SUBMISSION IN OBJECTION TO:

Application Name:
Sydney Church of England Grammar School (Shore)
Extension of Shore School onto Graythwaite Site

Application Number: Concept Plan (MP10_0149) and Stage 1
Project Application (MP10_0150)

Current view from Bank St residence to Graythwaite site highlighting family swimming pool area

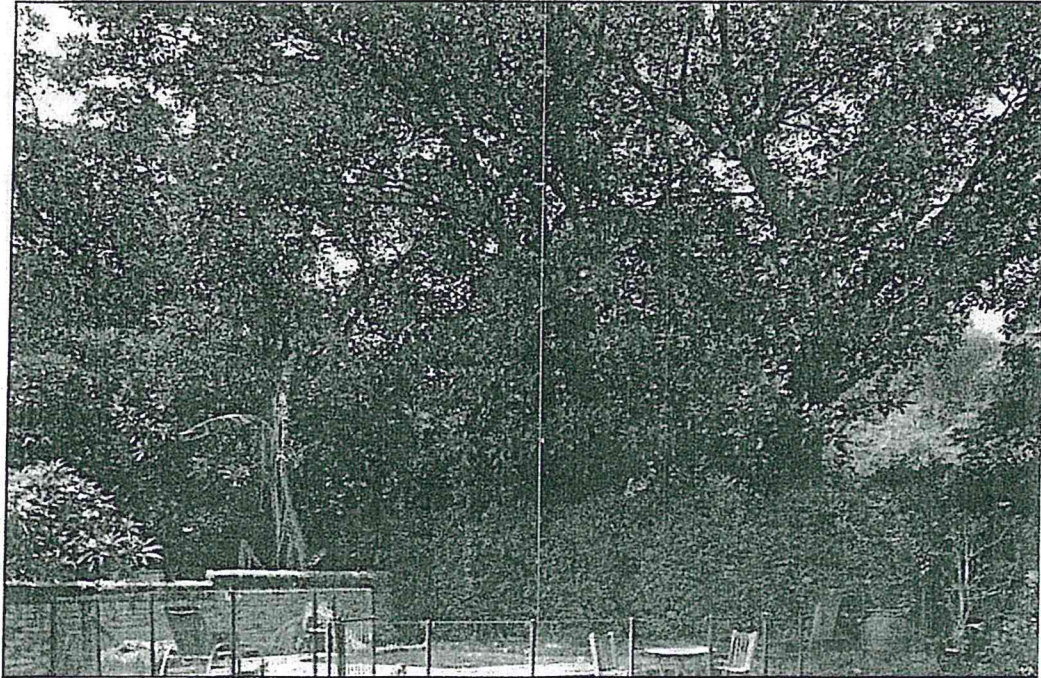
If this proposed development in particular the building of the new West Building proceeds my family including my 11 year old daughter, will have to carry out our normal daily activities with up to 400 young boys and teenage boys looking directly into our home and watching our every move.

The proposed foundations and ground floor of the proposed West building are 16 metres off our back fence but start at a level higher than the roof of our 2 storey house which is approx 5 metres higher than our back door.

The building is 14 metres tall and finishes approx 20 metres in height above our back door and backyard.

View from Bank St residence to Graythwaite site showing the area the west building will cover

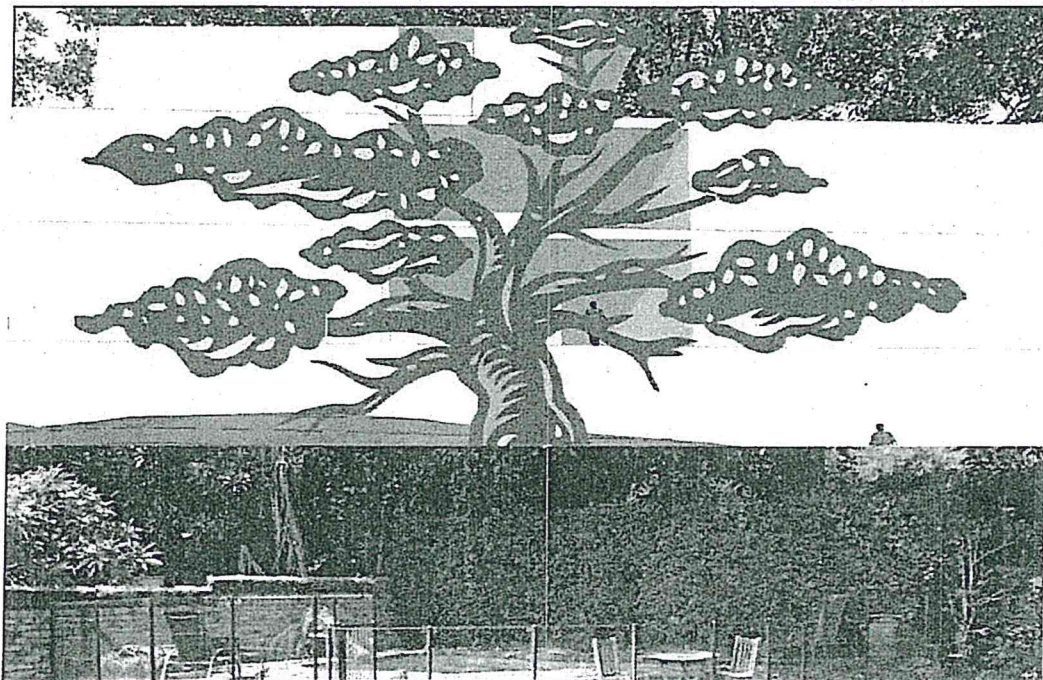
The proposed West building is 14 metres tall and spans approx 35 metres of the Bank St boundary (5 backyards) and is approx 35 metres in depth. Previously the

1. The proposed West building is set back 16.8 metres, however, because the land slopes up from the Bank St boundary the level of the foundations is approx 8 metres higher than the back door level of these homes, which takes the real height of the building to over 20 metres higher than the back door of the homes. Therefore, the entire building is in full view of the Bank St properties and further, the west building takes over the entire view from these Bank St homes and overlooks directly into these homes even through roof skylights and glass atriums.

At a minimum, the development should be scaled back in overall size, have a max height of 8 metres and sited further up the slope starting on the eastern line of the headmasters house at the very least.
